Application No: M/20/22/HH  
Site Address: 48 Lane End Road Middleton-on-sea PO22 6LT  
Description of works: The construction of an additional storey, rear single storey extension and detached garden building.

Thank you for your internet representation made on 25th April 2022 which has been recorded as an objection with the comments as follows:

Summary of email+photos sent to K Welch

client	project	drawing	date	drawn	drawing no	revision
Jane Cutts	Extension at: 48 Lane End Road Middleton-On-Sea, PO22 6LT	Proposed elevations	Oct 21	pd	0358 / 102	D
			scale 1:100 @ A3	CAD file name:

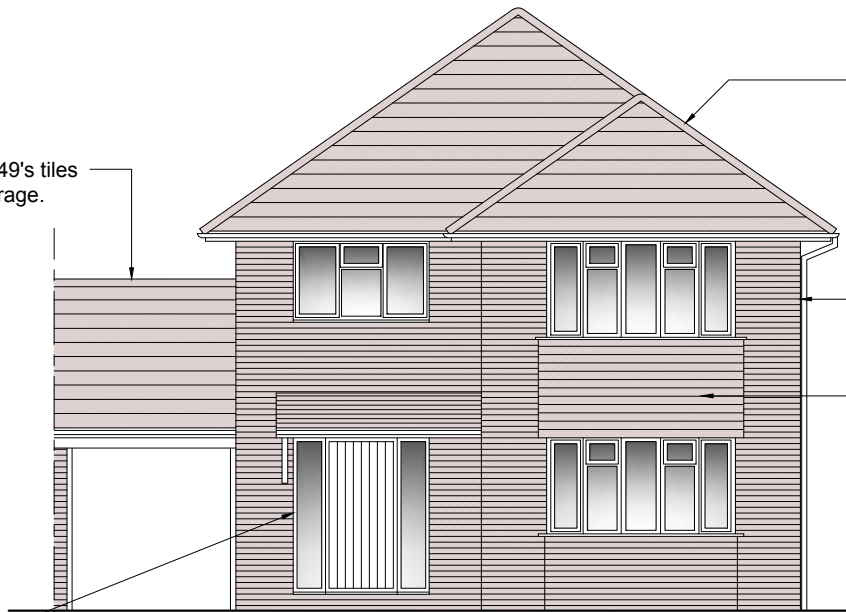
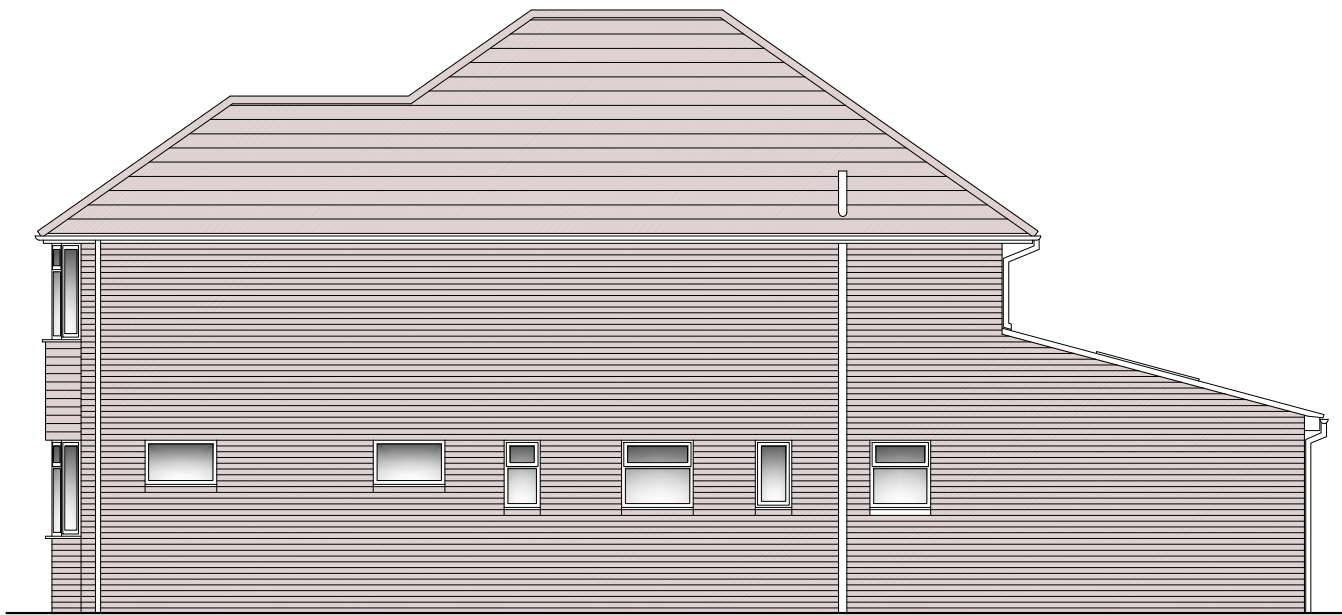
We are not objecting in principle to a garden room+extension. We object to creating a full two-storey house on a long road of standard-construction bungalows. Although the second storey extension will retain the footprint of the original, as it is not pitched it will tower over their adjoined neighbour and will restrict light to both 50 and 52 particularly in winter.

The neighbours at 50 built a garage room not a loft extension to avoid privacy issues so the fact that there is planning permission is irrelevant. We are already overlooked by number 46's extension so we would be overlooked by number 48. 48 is only overlooked by a house on the Layne because the Cutts removed several trees that provided privacy to 48 and 50.

The north of Lane End Road and the rest of this development (including Kingsmead Rd and Sunnymead) is all bungalows. The Cutt's 2-storey house will stick out (photo in email).
